From: Liz Galloway [redacted]
Sent: 12 May 2014 17:06
To: Charlotte Burrows
Subject: RE: Further Information Required on Your Ref: PP-03345257 Our Ref: LU/124/14/HH
Attachments: 13091 BRYANT NICHOLS 52 St Marys Close-01. EXISTING A1.pdf; 13091 BRYANT NICHOLS 52 St Marys Close-02 PROPOSED A1.pdf

From: Charlotte Burrows [mailto:Charlotte.Burrows@arun.gov.uk]
Sent: 12 May 2014 16:12
To: [redacted]
Subject: RE: Further Information Required on Your Ref: PP-03345257 Our Ref: LU/124/14/HH

EXISTING ELEVATIONS 1:100

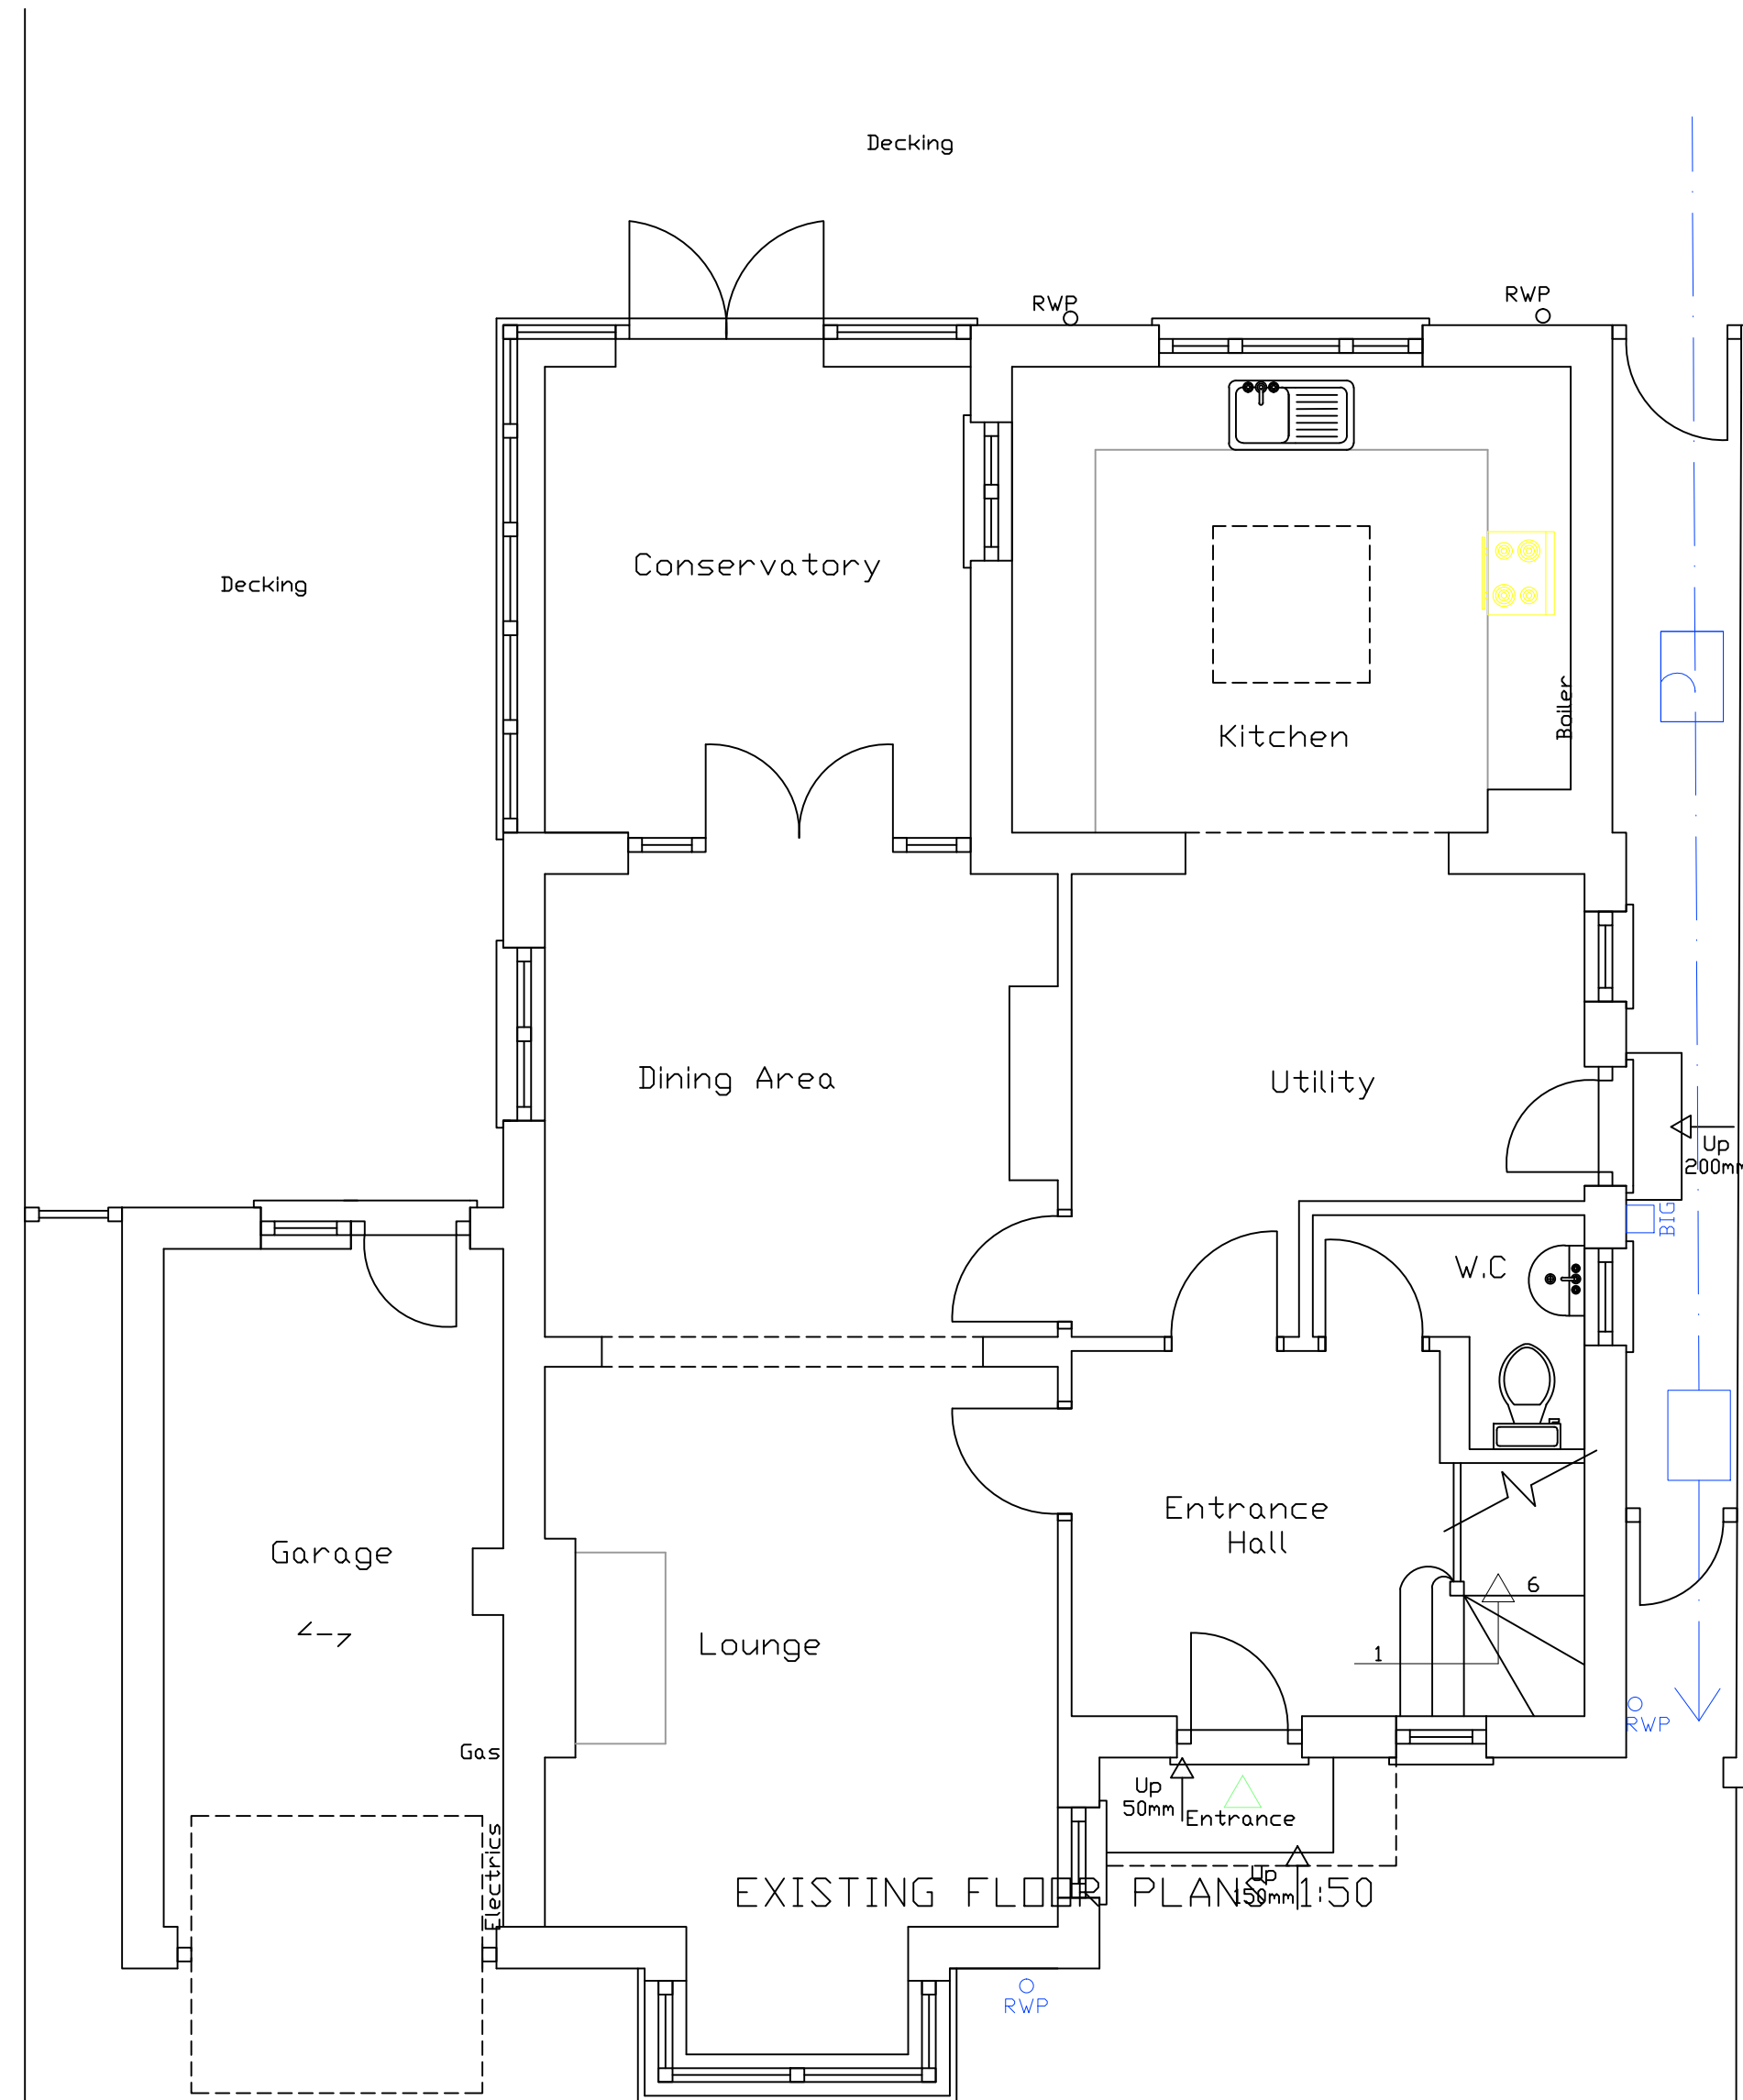
Unfortunately we still require the revised Existing elevations plan as the small garage door and window have been indicated on the floor plan but not the elevation. Also the amended plan 13091/02 (Proposed plans) no longer indicates the garage door, therefore the floor plans and elevation do not accord. Please amend accordingly.

Please find amended drawings as requested.
